Lancashire Archaeological  
Advisory Service

Your ref: 3/2018/0013

Date: 29th January 2018

**Planning Application 3/2018/0013: External repointing using lime mortar, internal re-plastering using lime plaster, replacement of lead flashings to chimney stacks, replacement of damaged stone flags on front and rear roof pitches, removal of part of ridge beam above 29 Windy Street and replacement with new timber. Brabins Almshouses, 29-33 Windy Street, Chipping PR3 2GD**

drawing title:
Elevations

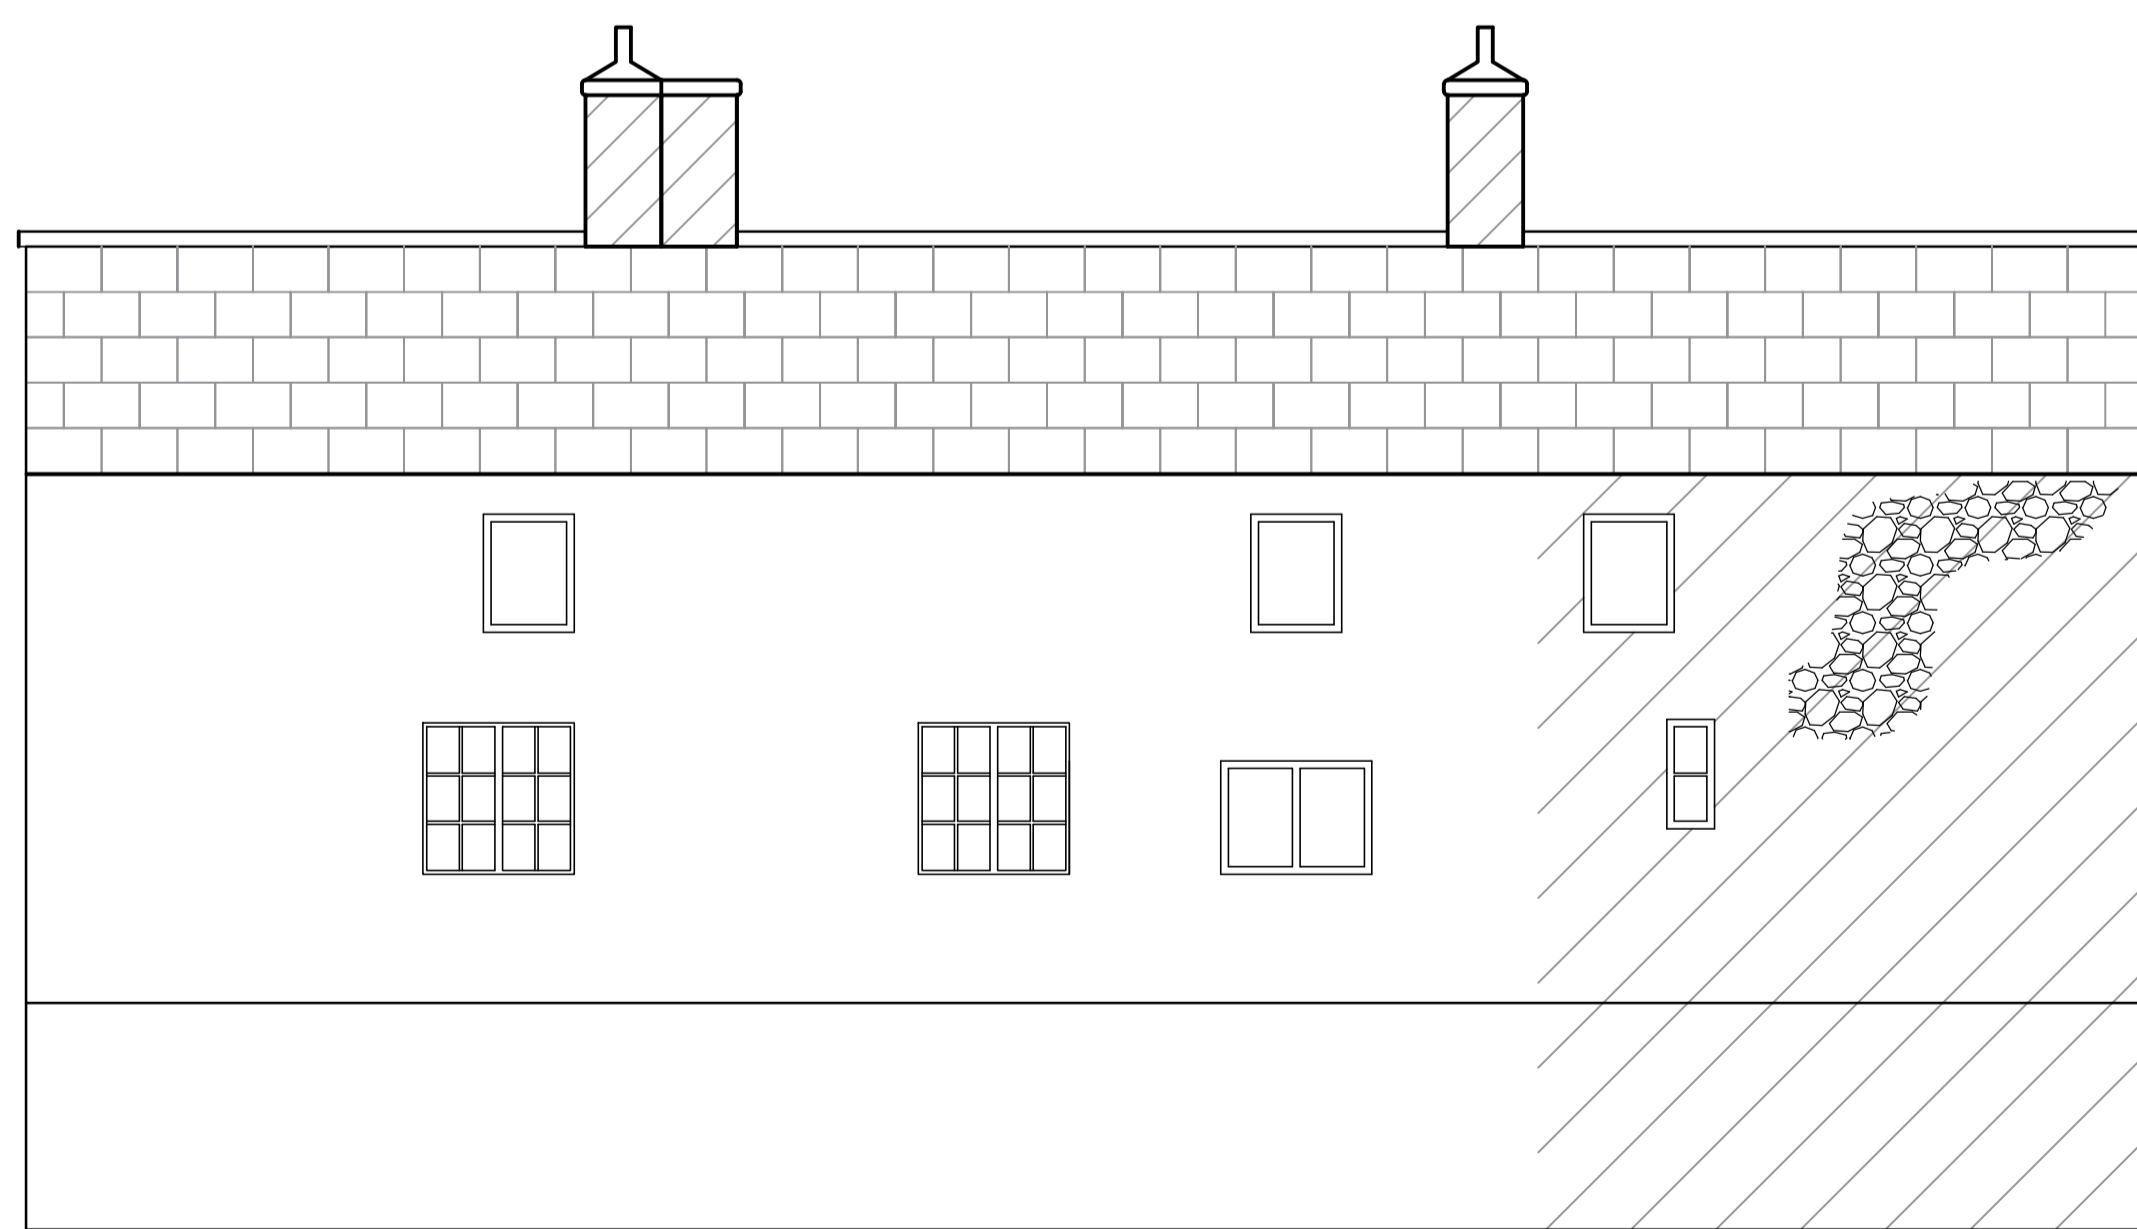
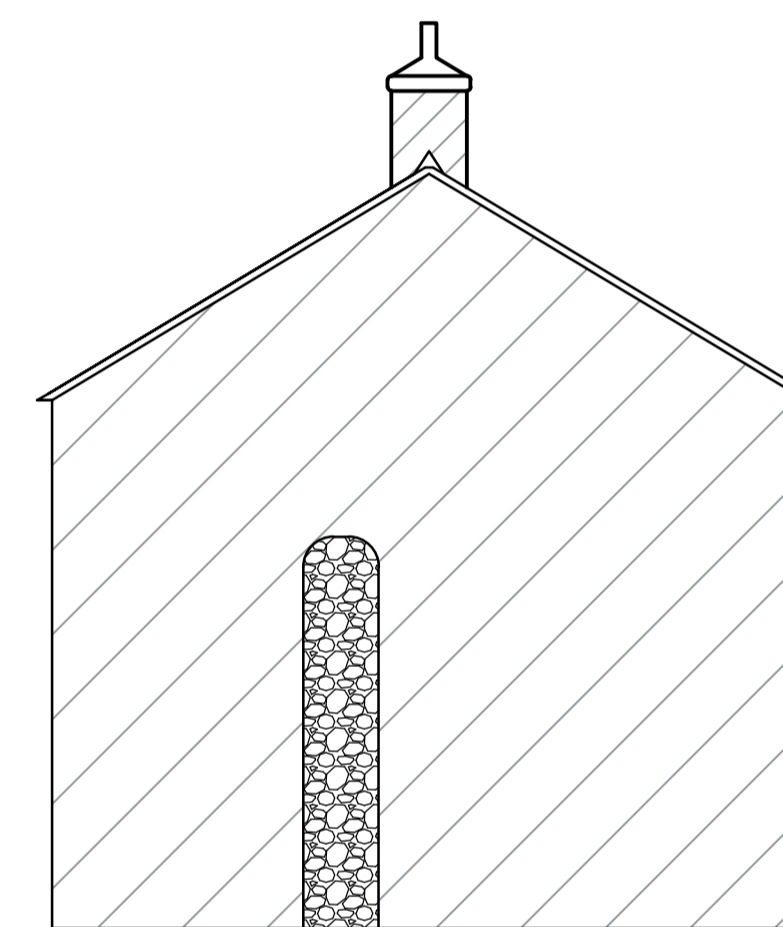
Thank you for your consultation on the above application. The works as described in the application and planning statement appear appropriate as far as they go, although further details of the proposed timber repair and the lime mortar and plaster mixes would have been useful. If these details can be agreed with Mr Dowd we would not have any objections to the proposals, nor would we consider that any archaeological recording is necessary.
